M25 junction 10/A3 Wisley interchange

TR010030

10.11 Schedule of Proposed Amendments to dDCO in Consequence of Proposed Scheme Changes

February 2020

Drawing Title	STREETS, RIGHTS OF WAY AND ACCESS PLANS REGULATION 5(2)(k) SHEET 4 OF 31
Drawing Number	TR010030/APP/2.4
Rev.	1
HE PIN: HE551522	Scale: 1:1000
Original Size: A1

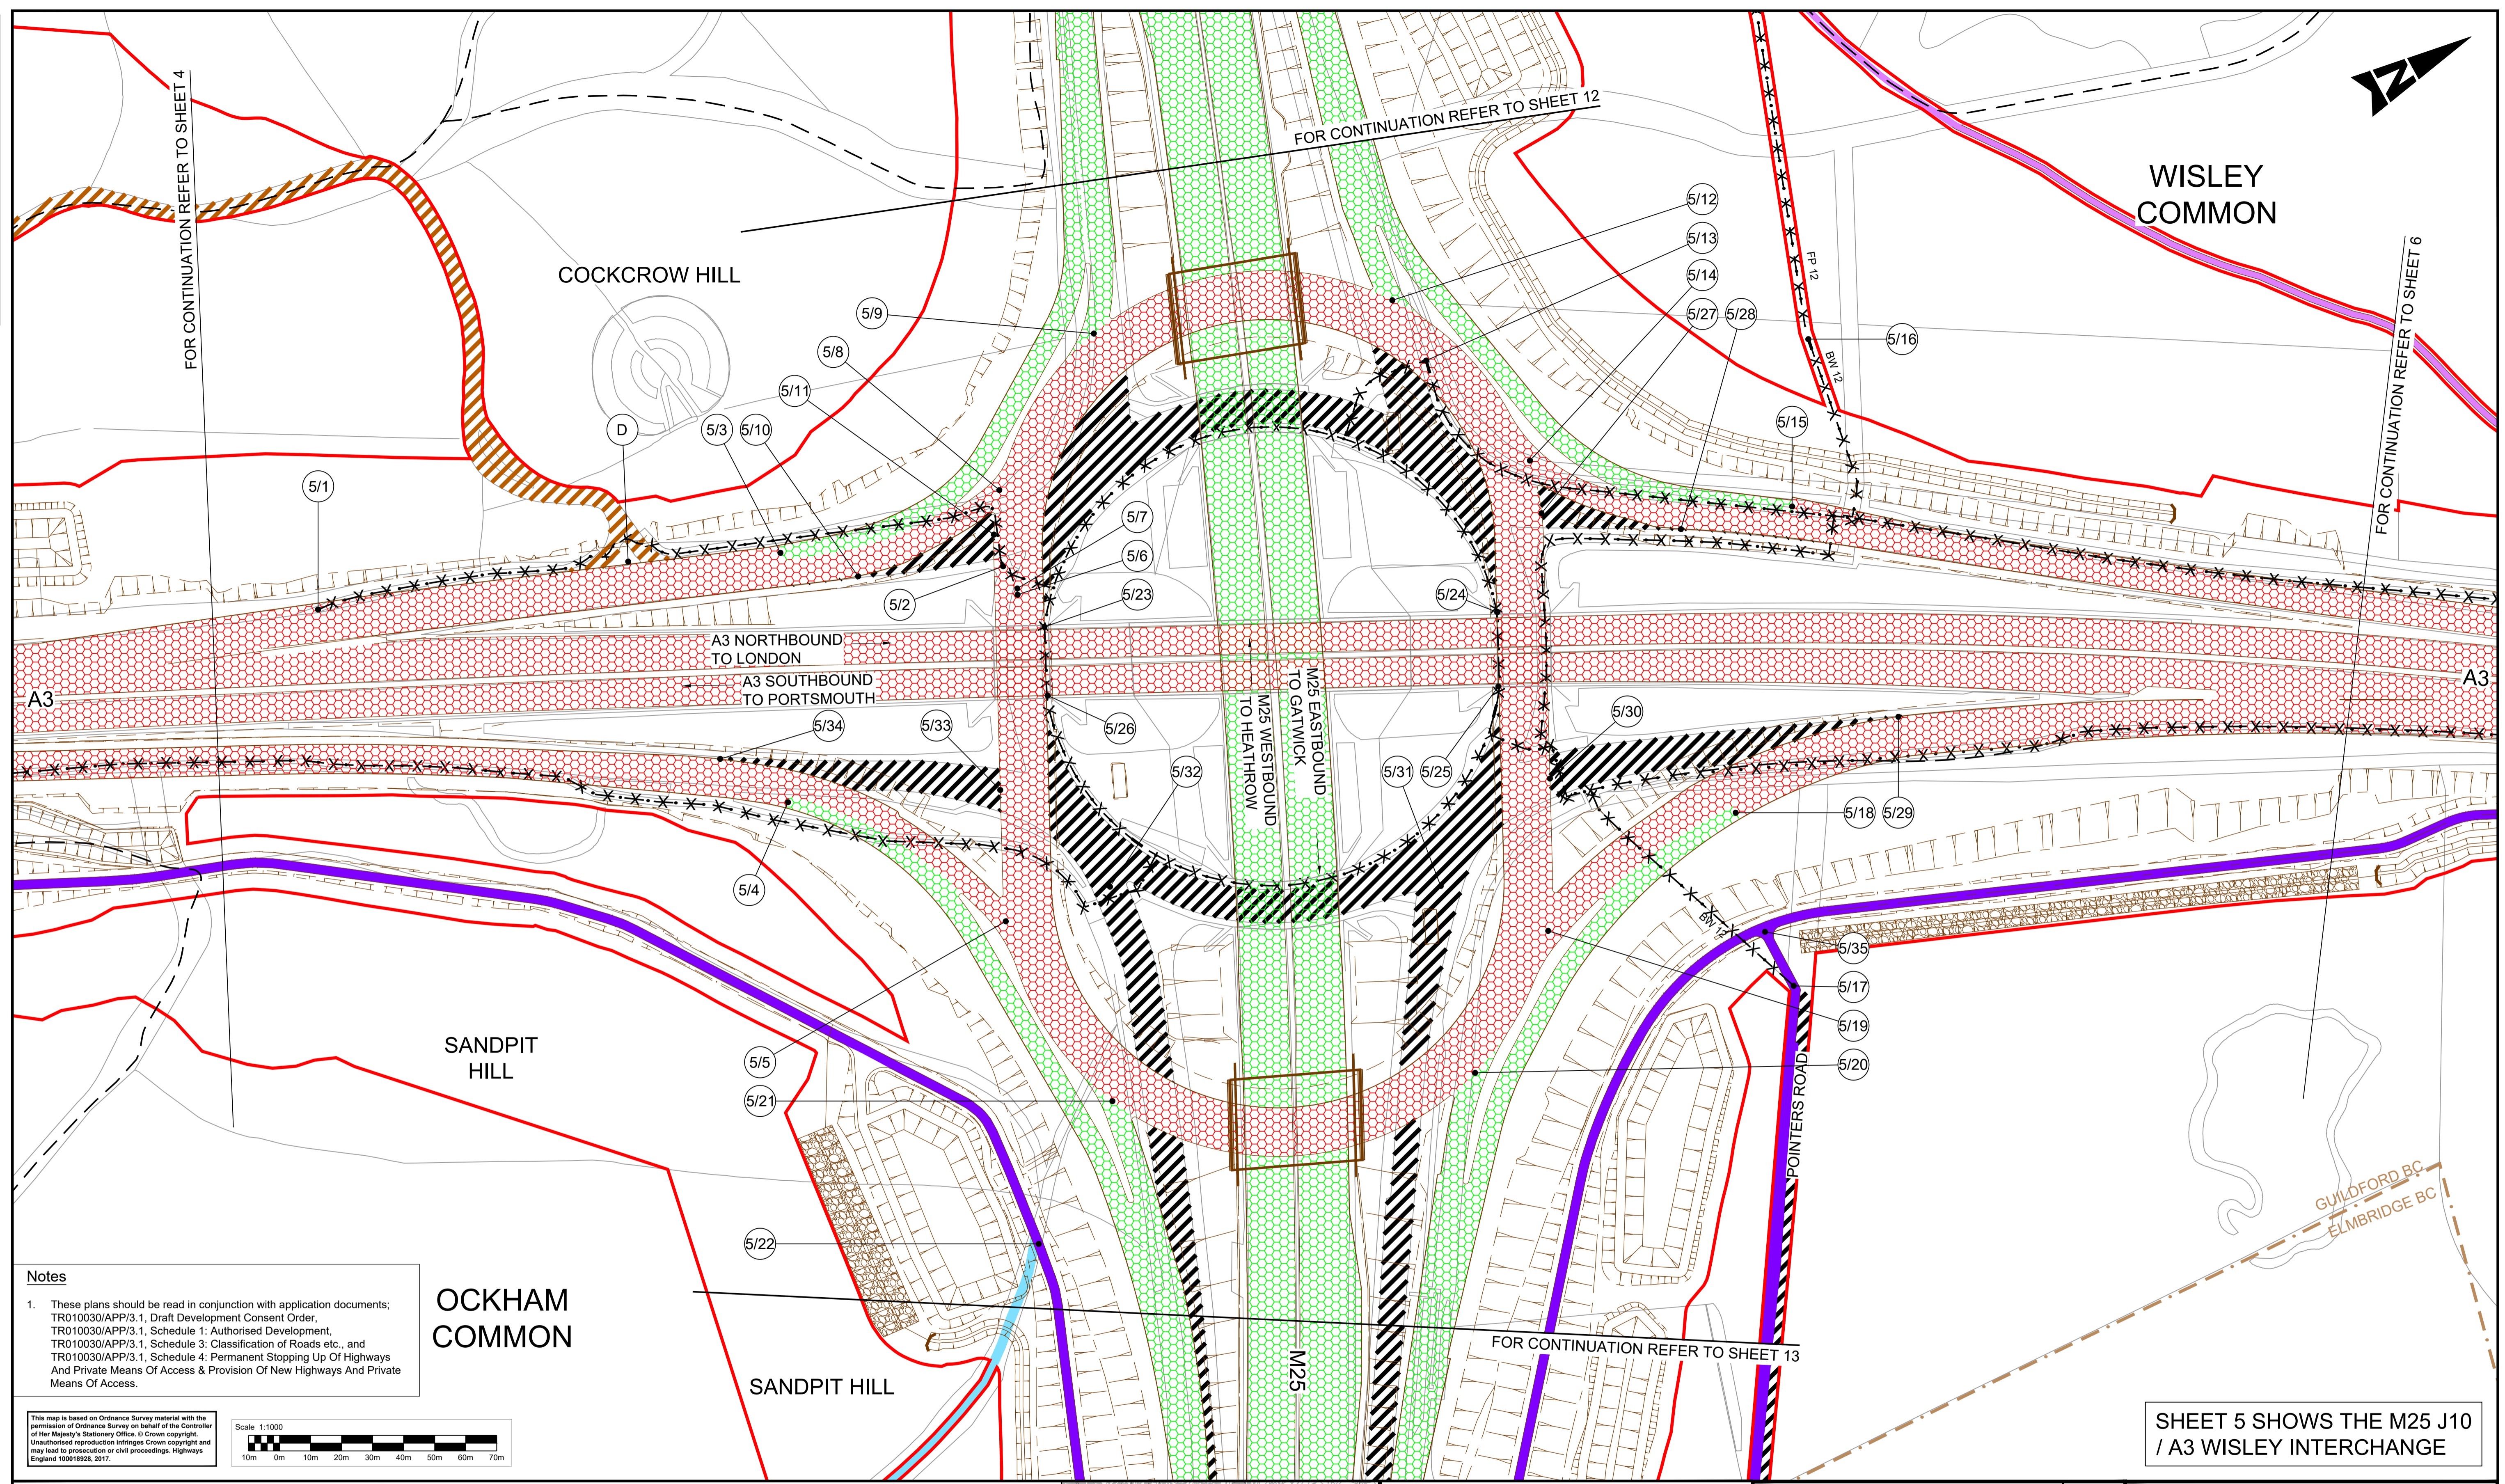
In the column (2) entry in respect of ‘Footpath’ in the fifteenth row on page 78, omit existing text and replace with “70 metres of footpath, as shown between points 4/9 and 4/14 on Sheet 4 of the Streets, Rights of Way and Access Plans.

Comment: These amendments are consequential on the extension of the green element to the proposed Cockcrow replacement overbridge.
